6 June 2013

RMS Ref: SYD12/00063/02
Department's Ref: MP08_0222 (MOD3)

**SECTION 75W MODIFICATION - GLOBAL SWITCH SYDNEY EAST PROJECT AT 273
PYRMONT STREET, ULTIMO**

**Landscape Plan
Roof Level**

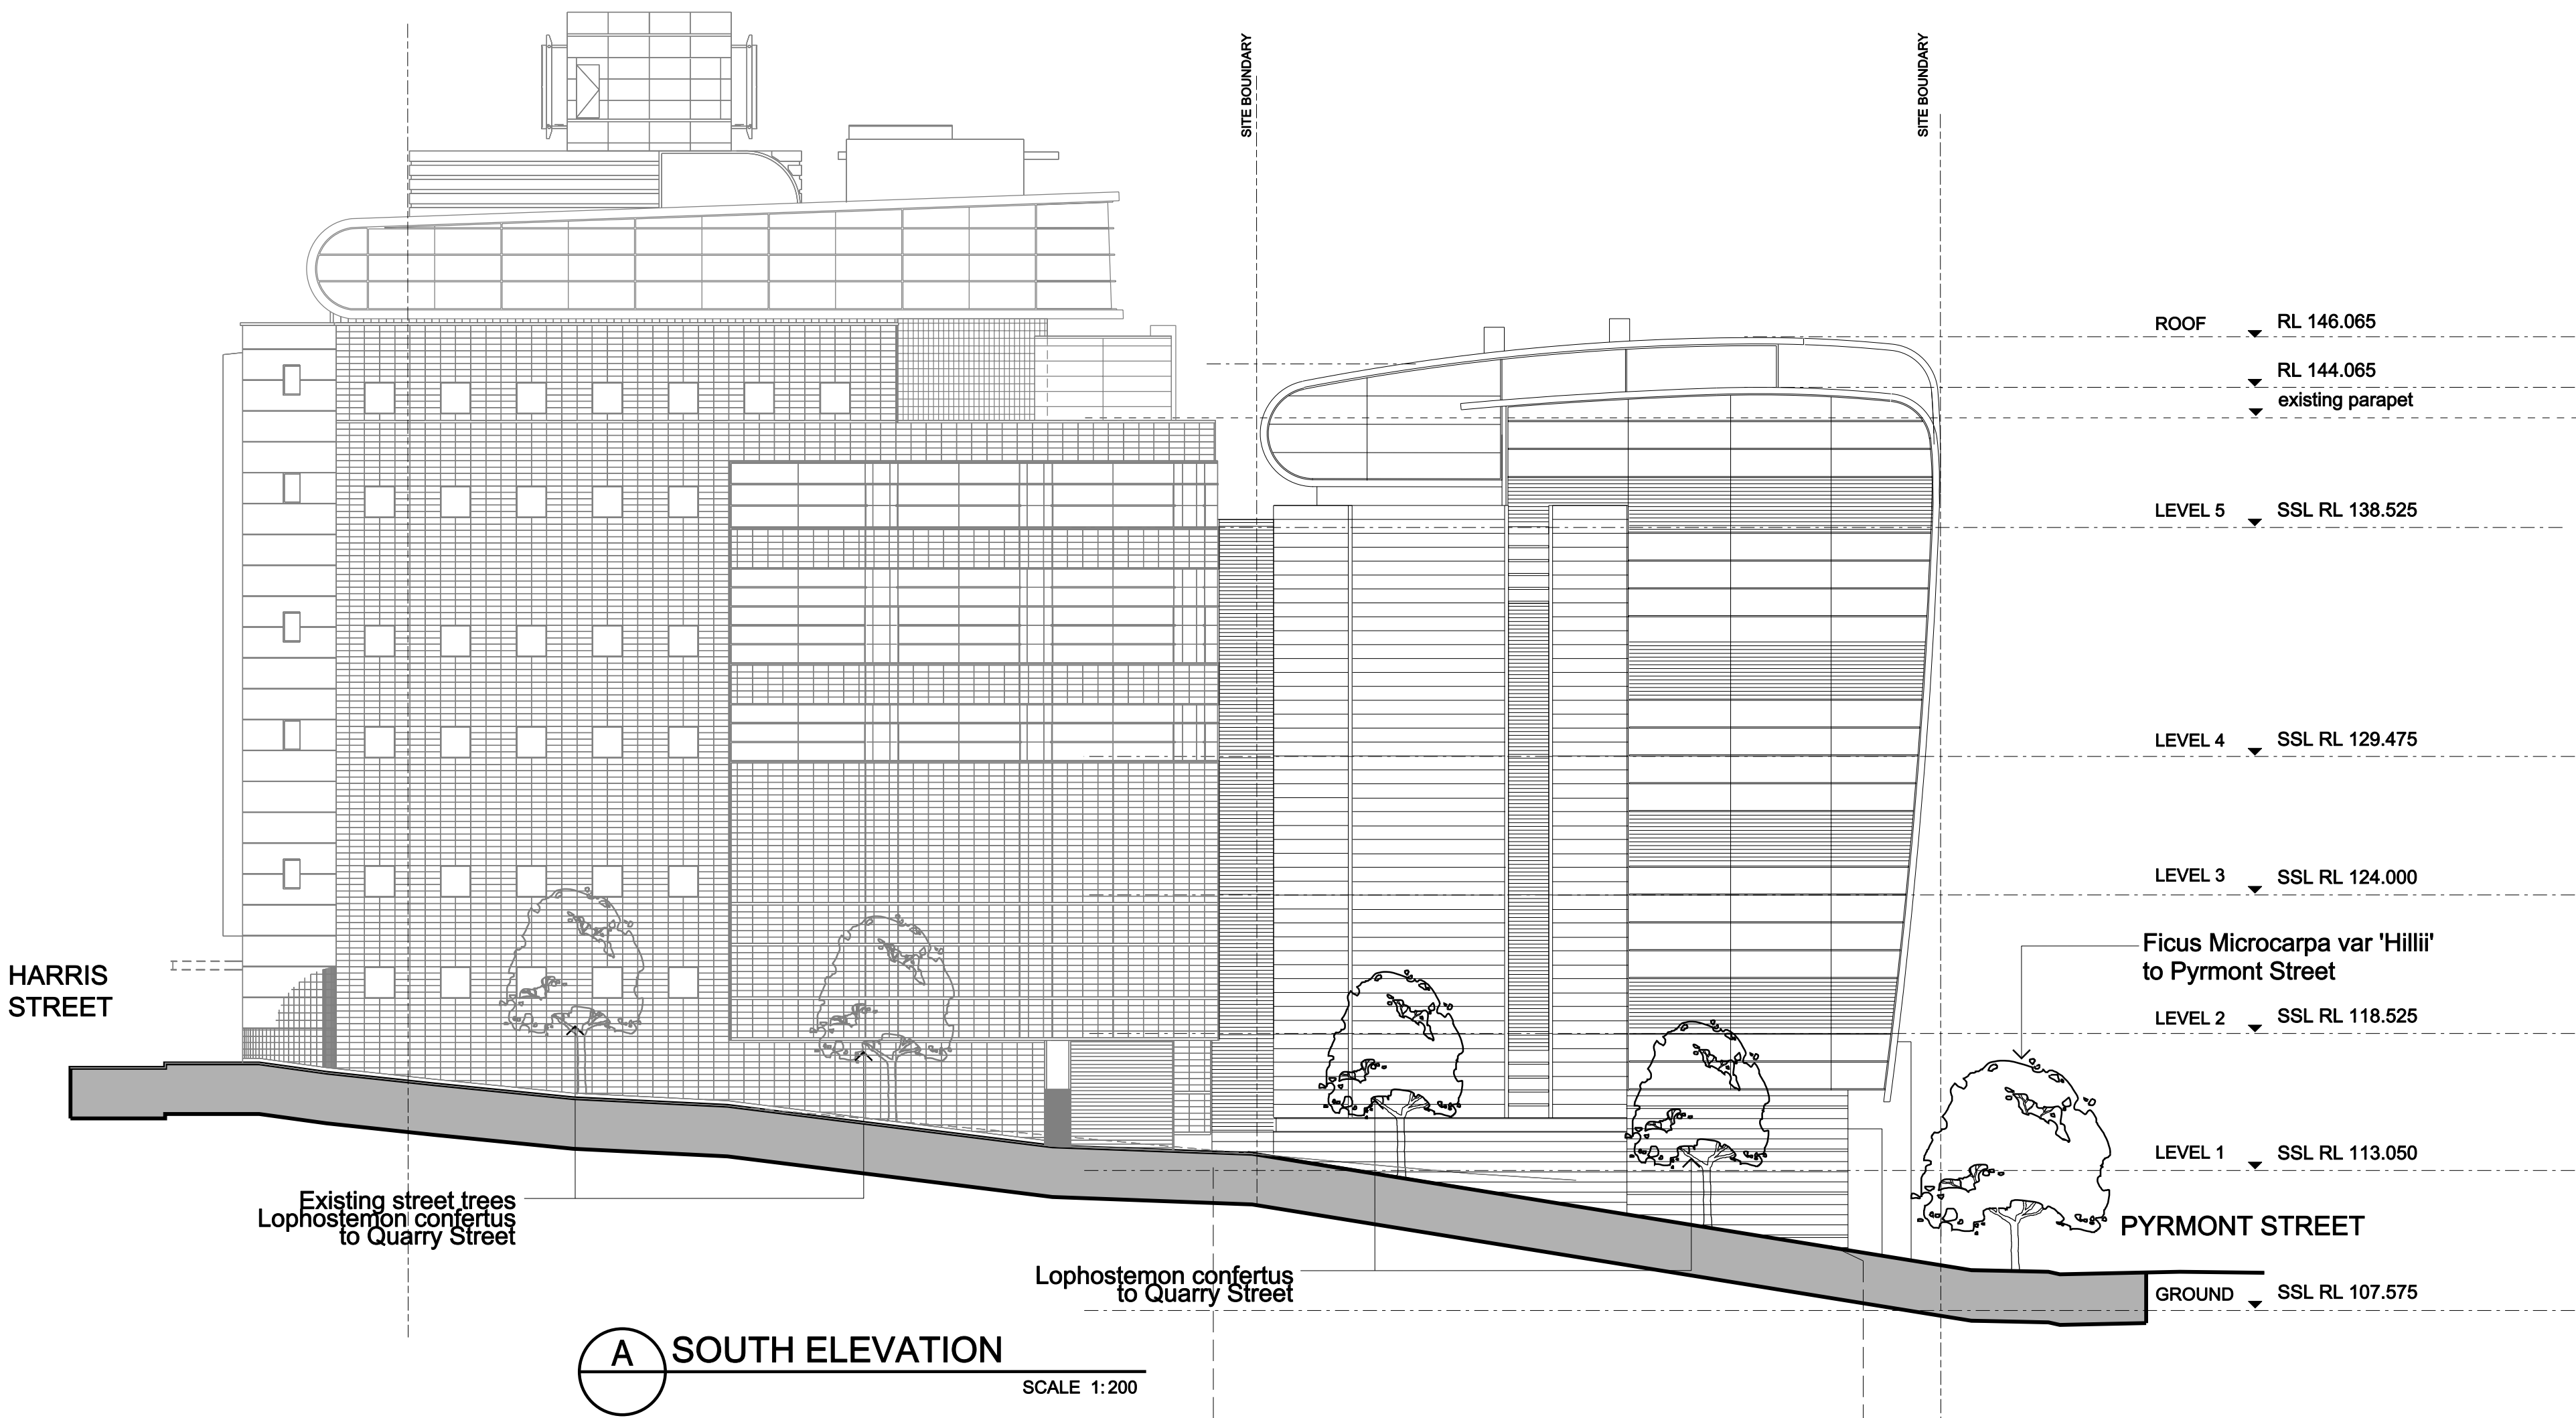
9. In order for RMS to carry out maintenance and rehabilitation works on the soffit of the bridge deck, access is required. To do this, the roof structure of the building needs to be able to carry a working load of not less than 4kN/m^2 . RMS would also need permission to access the roof.
